**Exhibition of Environmental Assessment for ASICS Warehouse and Distribution Centre -  
4 Darling Street Marsden Park (SSD-9153)**

## **Attachment 1: EPA comments and Recommended Conditions of Consent on the EIS for ASICS Warehouse and Distribution Centre, 4 Darling Street, Marsden Park**

Figure 3.1: Site Plan (Source: Reid Campbell)

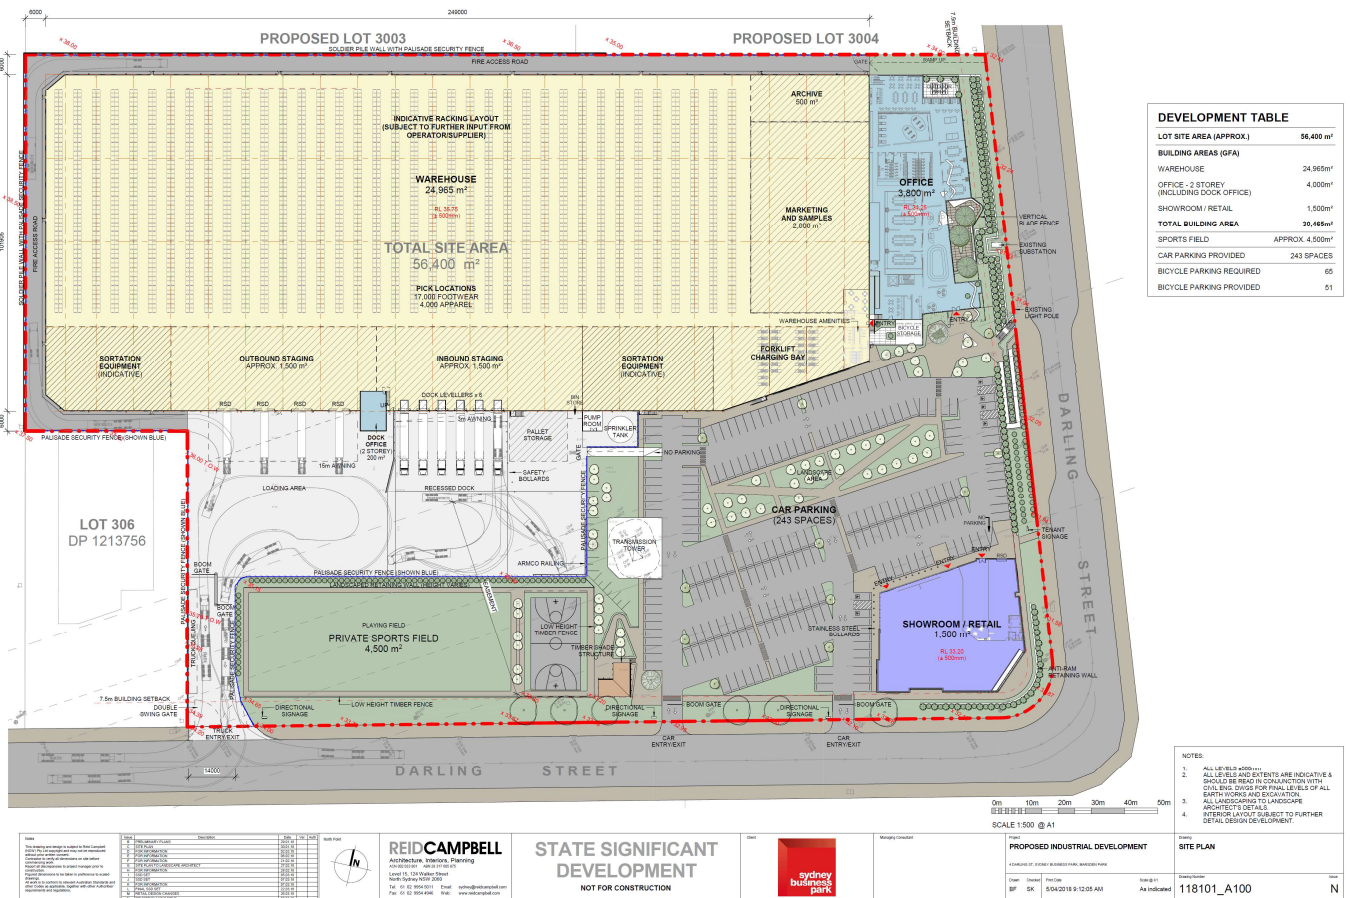
Generally, most of the figures presented in the EIS were not legible for reading. Perhaps increasing the figures to appropriate sizes will make the figures readable (e.g. figures 3.1, 3.2, 3.3, 3.4, 3.8, 4.2 etc.).
